From: Chantelle Bashford
Sent: 25 August 2020 11:18
To: Planning.Responses
Subject: RE: Planning Consultation on: BR/147/20/PL

Application No: BR/147/20/PL
Registered: 4th August 2020
Site Address: 53 High Street Bognor Regis PO21 1RX
Grid Reference: 493540 98976
Description of Works: Conversion of first & second floor & rear extension to create 4 No. 1-bed self-contained flats including the demolition of existing rear extension & erection of two storey rear extension. This application may affect the setting of a listed building & may affect the character & appearance of The Steyne, Bognor Regis Conservation Area. This application is in Cil Zone 4 (Zero Rated) as flats.

Drawing  
**Proposal Sections**

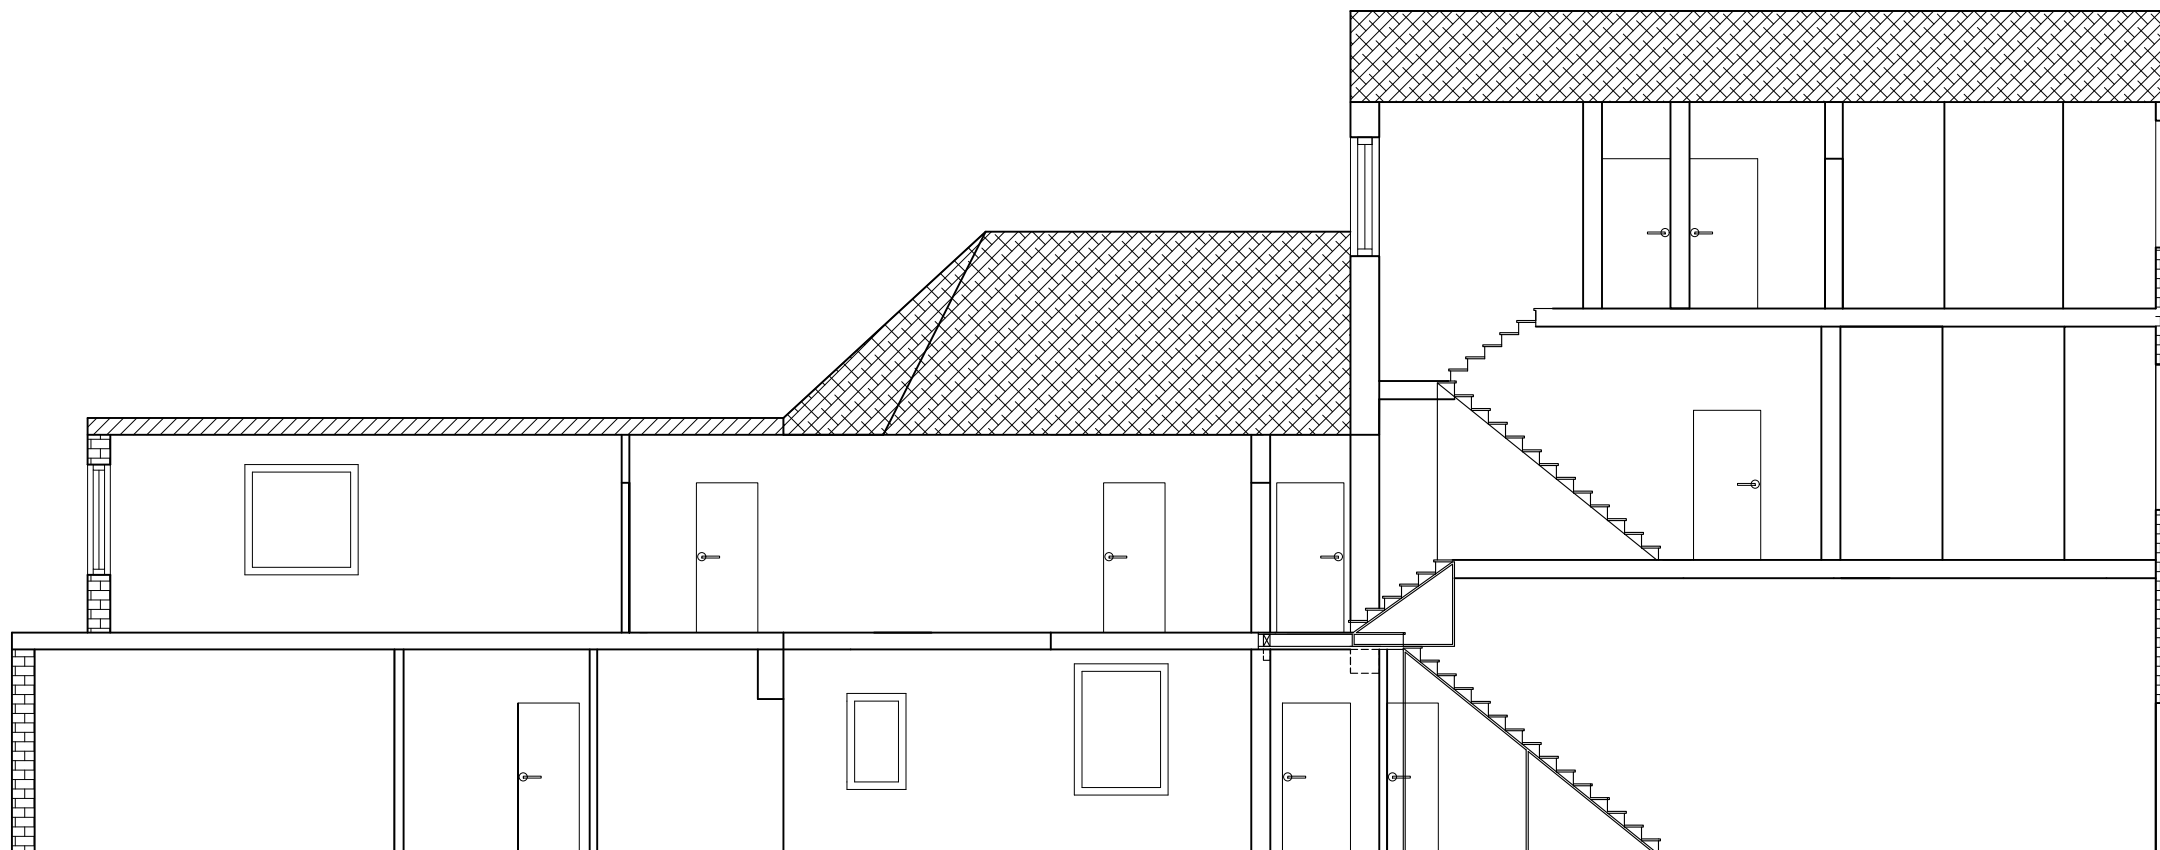
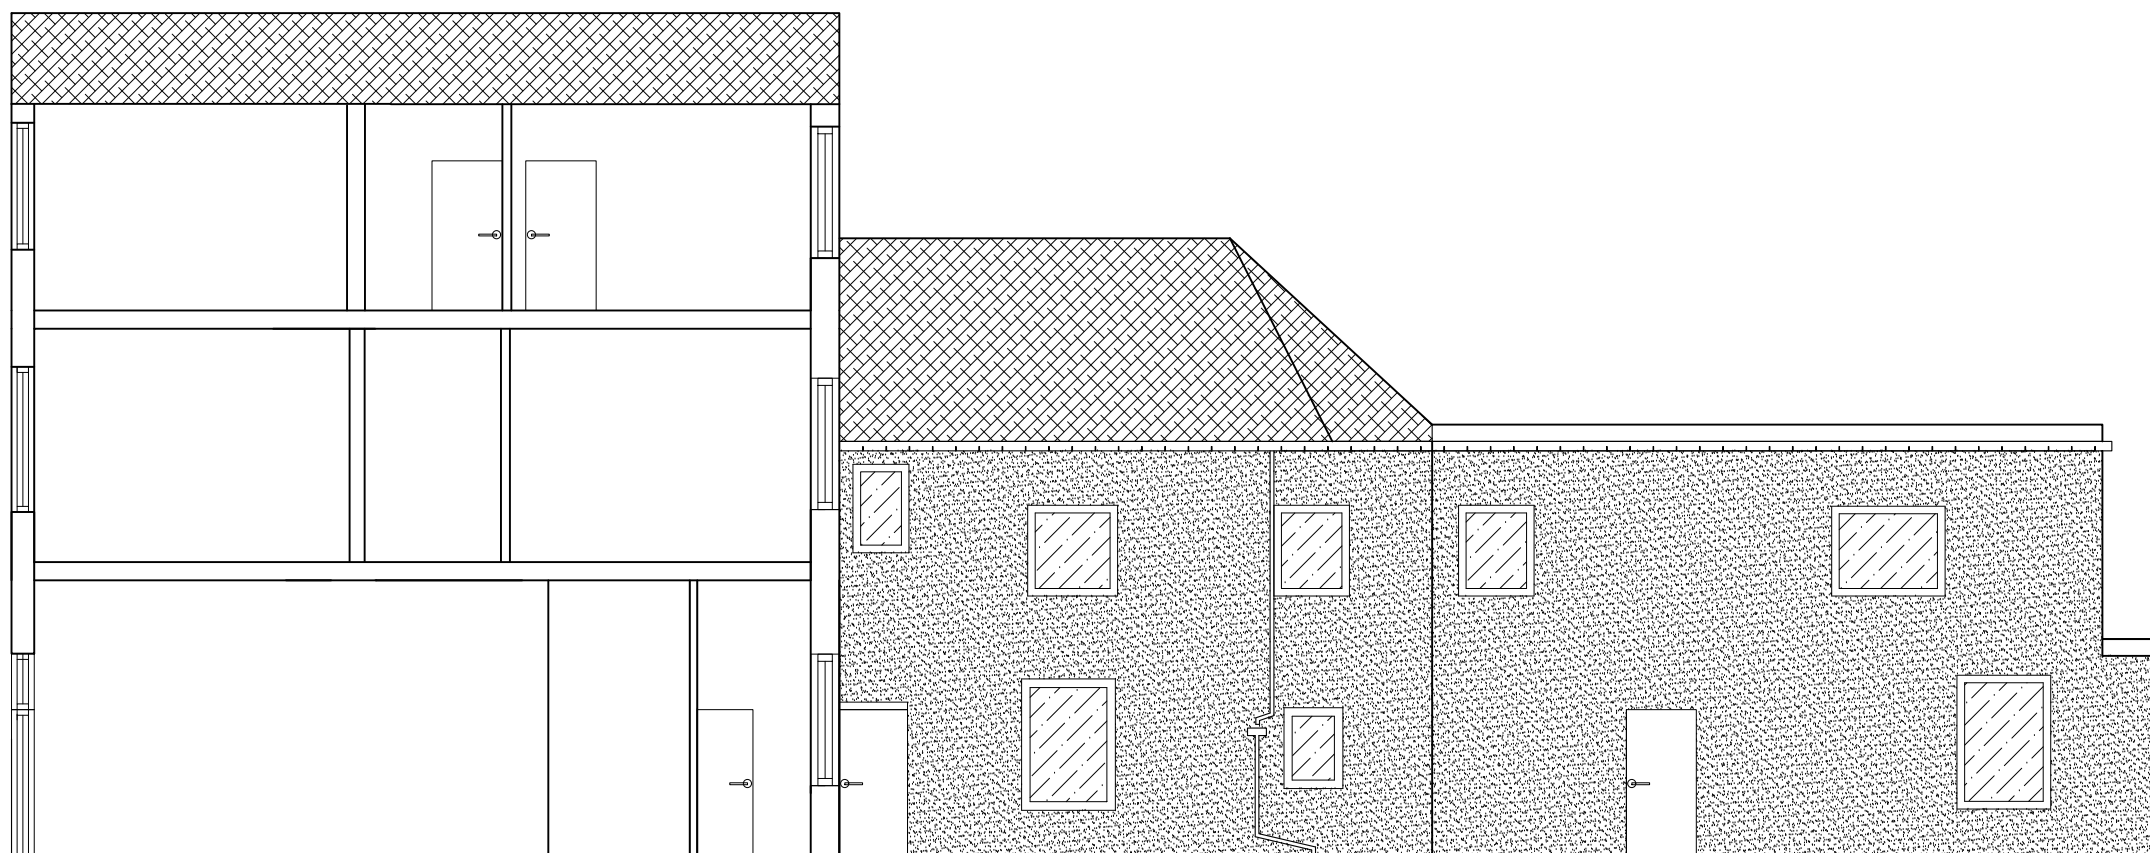
- There should be adequate 60 minute fire separation between the commercial unit on the ground floor and the surrounding residential flats
- 30 minute fire resisting escape route, including a 30 minute fire resisting and self-closing fire door (FD30S) to each flat entrance (except for flat 1 as this has its own private entrance) and to the service cupboard on the first floor landing if this houses any sources of ignition

- The cupboard under the stairs within the commercial unit should afford 60 minutes fire resistance to protect the escape route
- A mixed Grade A, LD2 and Grade D1, LD3 fire system should be maintained and installed
Grade A, LD2 system:
